An
Coimisiún
Pleanála

Direction
CD-022326-26
ABP-320627-24

The Commission decided to refuse substitute consent for the following reasons and considerations.

Site Layout drawing, Location 3, 1:1,000.

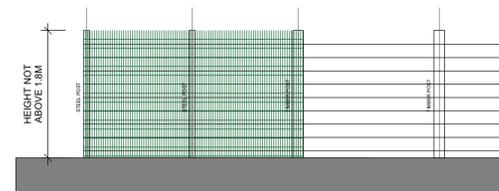
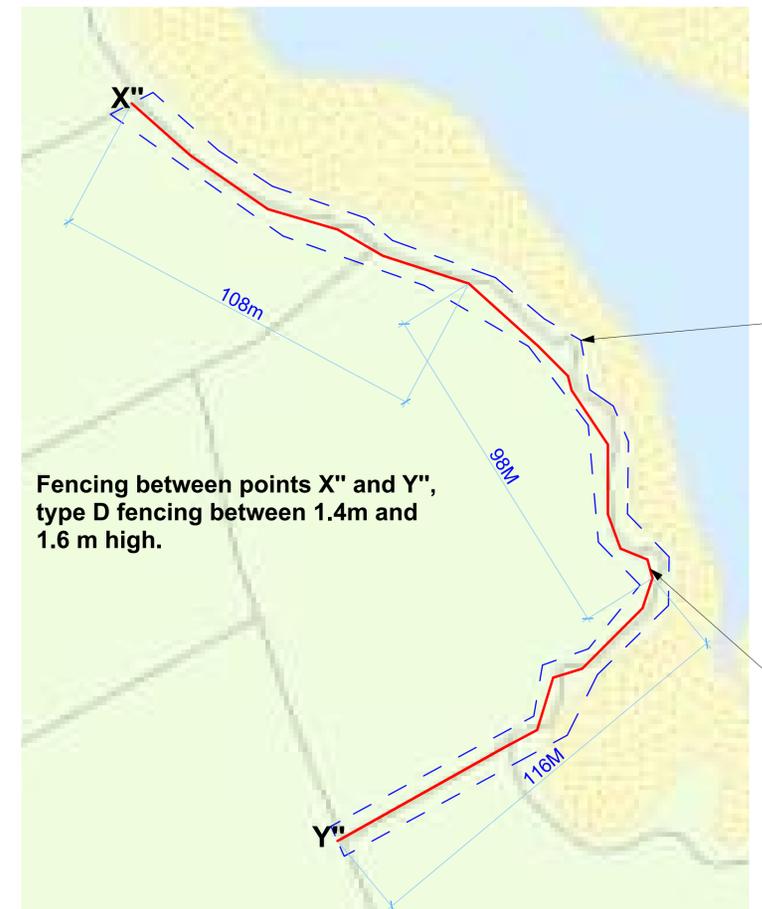
1. Having regard to the location of the proposed development within an area designated as a Visually Sensitive Area in the County Kerry Development Plan 2022-2028, it is considered that, by reason of its design, including up to 1.8m high post and wire fencing (with a mix of timber, steel and galvanised posts) and up to 1.8m green painted mesh fencing with steel posts, and to the linear extent (c. 1686m) and visual prominence along a coastal setting on Fenit island, the proposed development would result in an unacceptable adverse impact on the character, integrity, distinctiveness and scenic quality of the receiving landscape. The proposed development would therefore fail to protect the landscape and visual

In deciding not to accept the Inspector's recommendation to grant permission, the Commission did not share the inspector's view that the proposed fencing constituted minor development or that its retention would not result in an adverse impact on the character or scenic value of the island landscape. Furthermore, the Commission did not agree with the inspector's conclusion that the retention of the fencing would not adversely affect the setting of any archaeological feature or landscape. The Commission concluded otherwise that the fencing development, by reason of its design and visual prominence along a coastal setting on Fenit island, would have an unacceptable adverse impact on the character, integrity, distinctiveness and scenic quality of the receiving island landscape and would be contrary to Objectives 11-76, 11-77 and 11-78 of the Kerry County Development Plan 2022-2028. The Commission also found, contrary to the inspector's finding, that the development would also detract from the character and setting of the archaeological heritage of the area and would therefore be contrary to Objective 8-27 of the Kerry County Development Plan 2022-2028.
